Recommendation Report for Planning Permission**REF NO:** LU/228/15/PL**LOCATION:** 10 St. Catherines Road
Littlehampton**PROPOSAL:** Conversion of Ground & First floor at the rear into two 2 bedroom flats.
Resubmission of LU/71/15/PL**SITE AND SURROUNDINGS**

Drawing 4 / 6

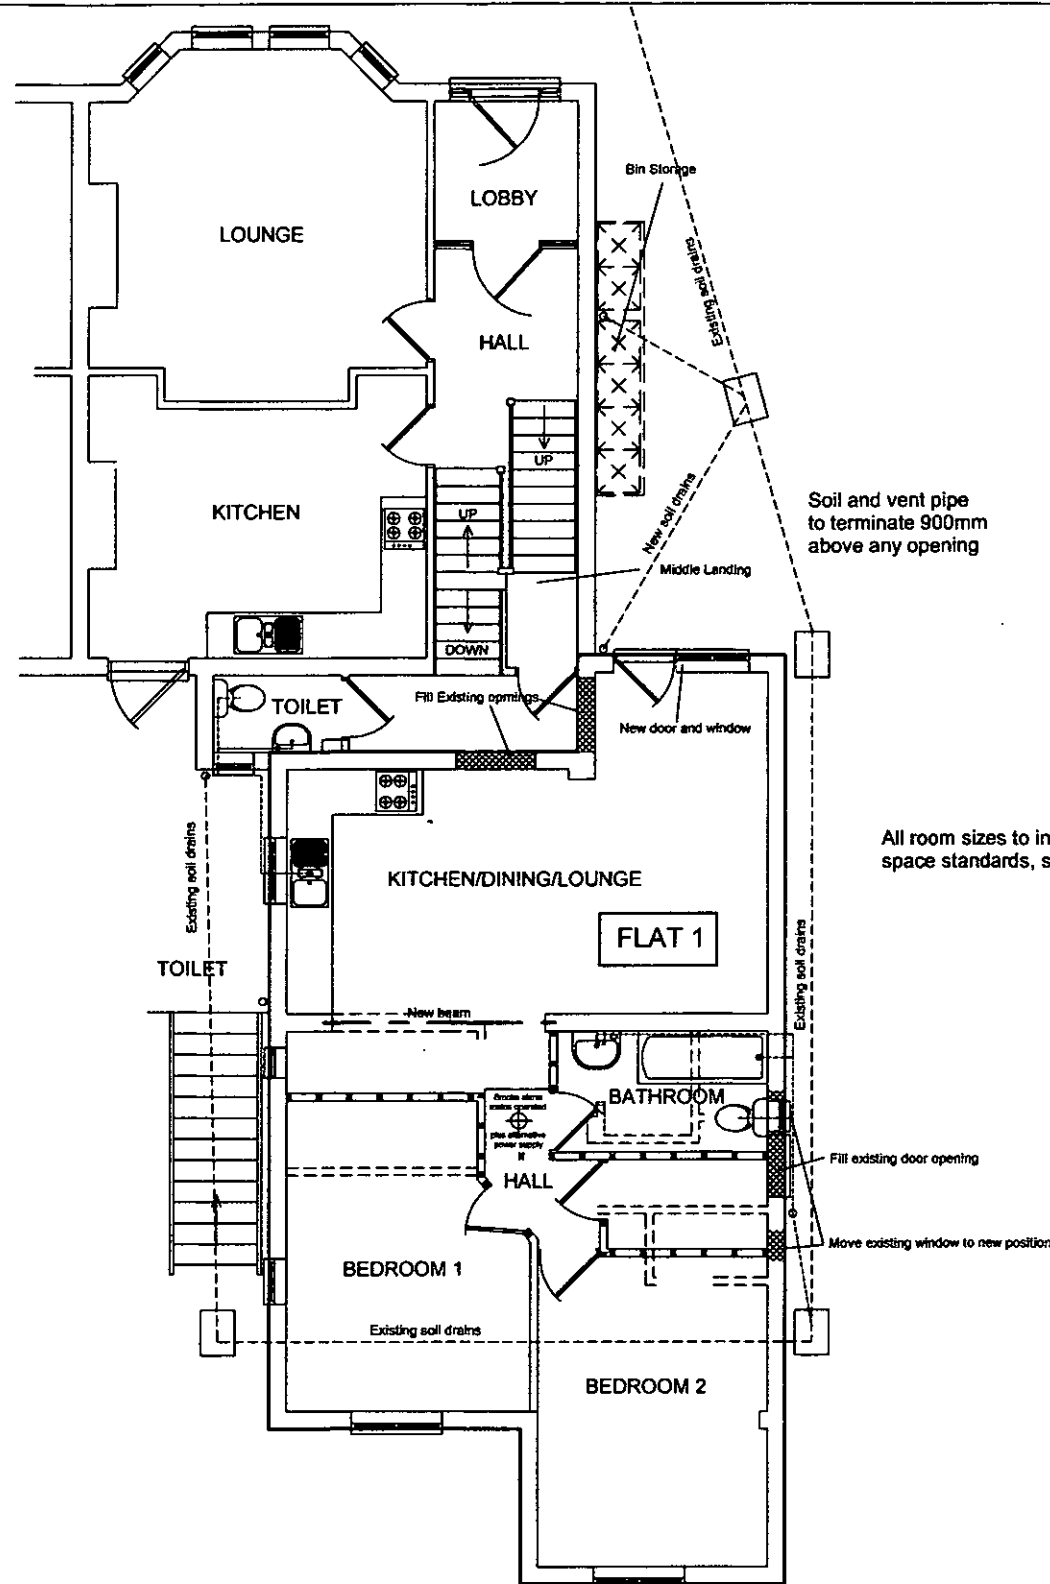
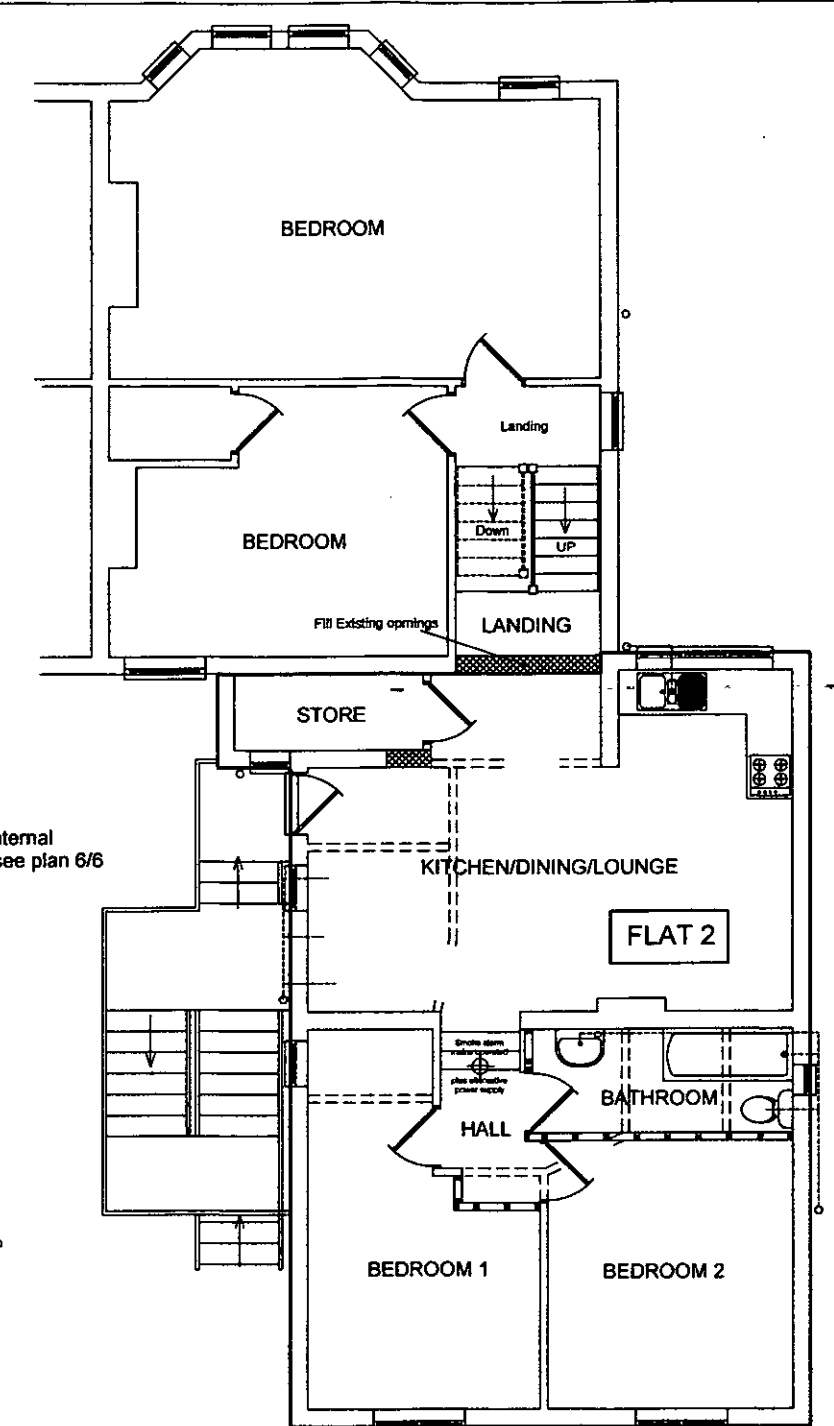
This application has been submitted following refusal of LU/71/15/PL. The application was refused on the basis that the internal room sizes did not accord with the Emerging Local Plan. The agent has now increased the floor area of both flats. The lift has been removed to create more space within both flats and the floor area of Flat 2 has increased to include part of the landing and an existing toilet.

the use of the remainder of the premises. The extension to the rear appears to be of fairly recent construction. The application forms relate to the previous use being a rest home. The Flood Risk Assessment refers to use as an House in Multiple Occupation. There is no recent planning history. Conversion of part of the premises into flats is acceptable in principle in this location. The overall internal floor area for each flat would meet the minimum essential general internal floor area for a 2 bedroom 3 person single storey dwelling/flat as set out in policy DDM2 of the Emerging Local Plan. The standard is 61 sqm. Flat 1 has an internal floor area of 62sq and Flat 2 of 61sq m.

Drawing 6 / 6 INTERNAL SPACE STANDARDS

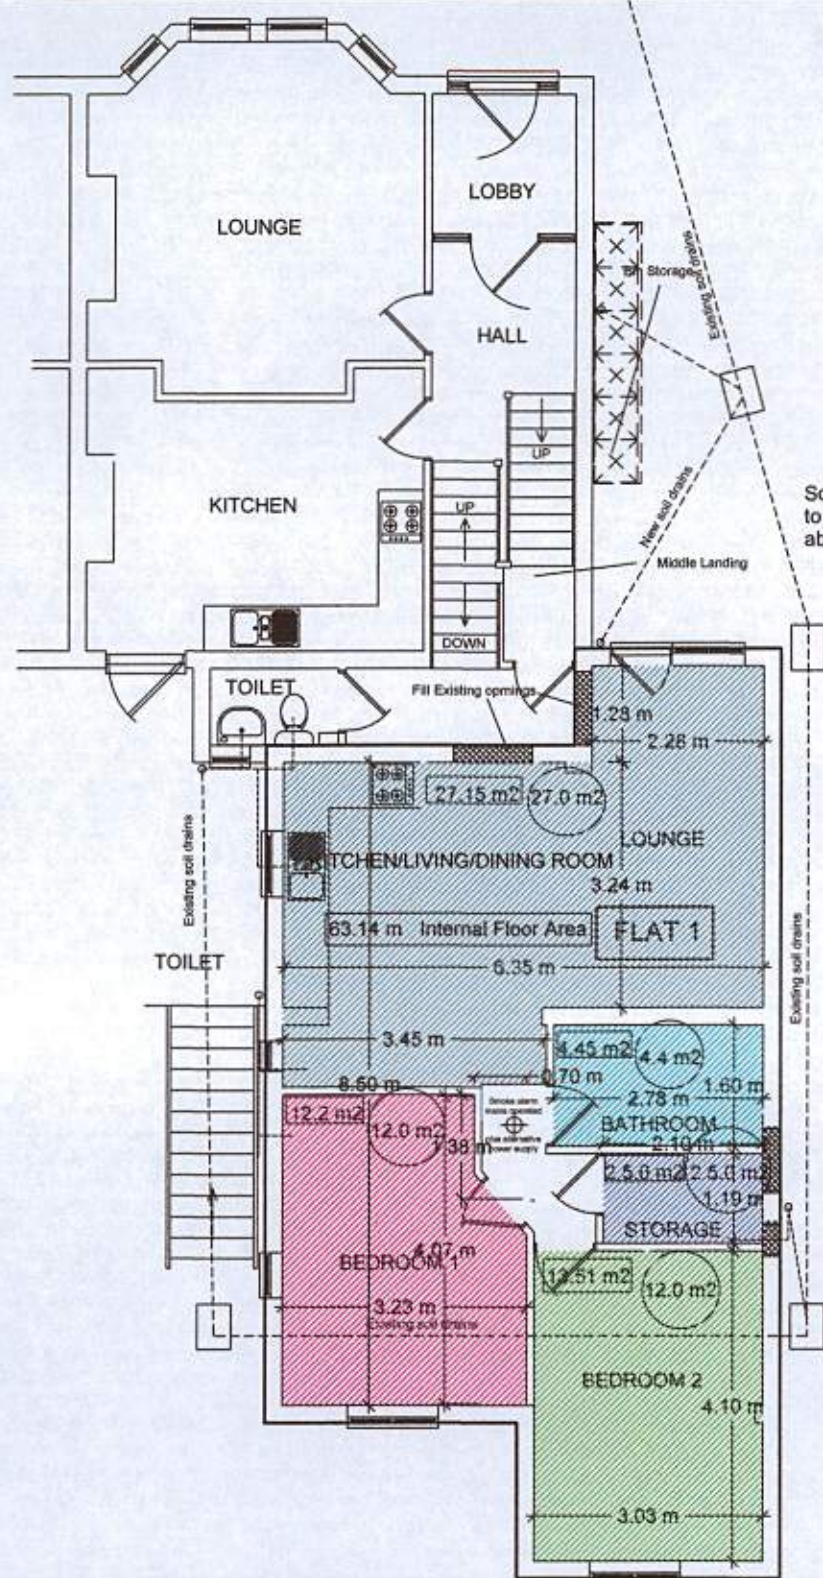
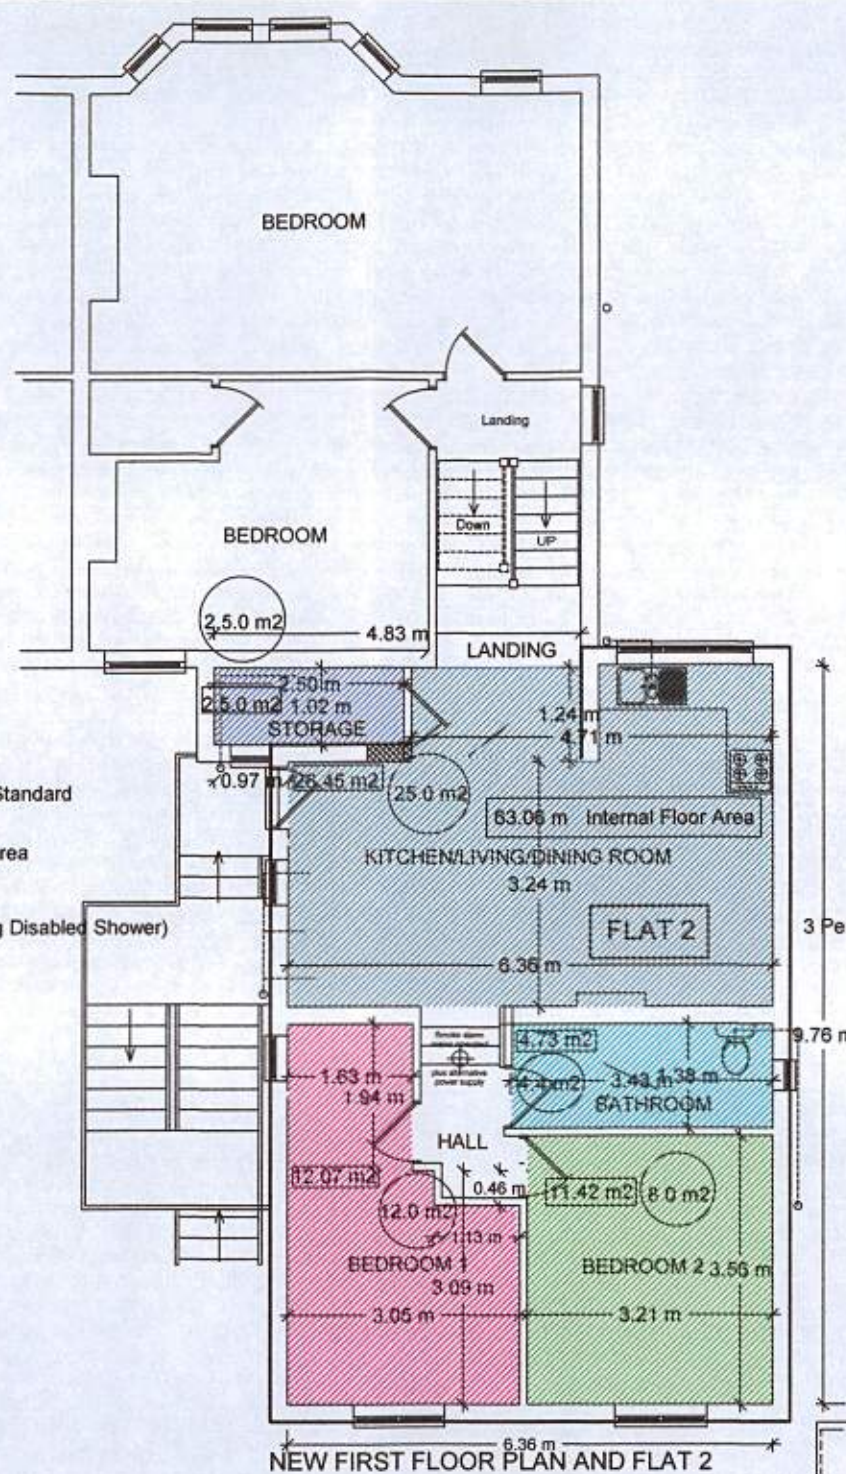
The proposed development is considered to be comply with the emerging internal space standards. The space standards set out minimum requirements that are considered acceptable for all occupants and their changing needs. The proposed development meets these standards. The proposal would therefore be acceptable in terms of residential amenity of potential occupiers in compliance with policy GEN7 of Arun District Local Plan.
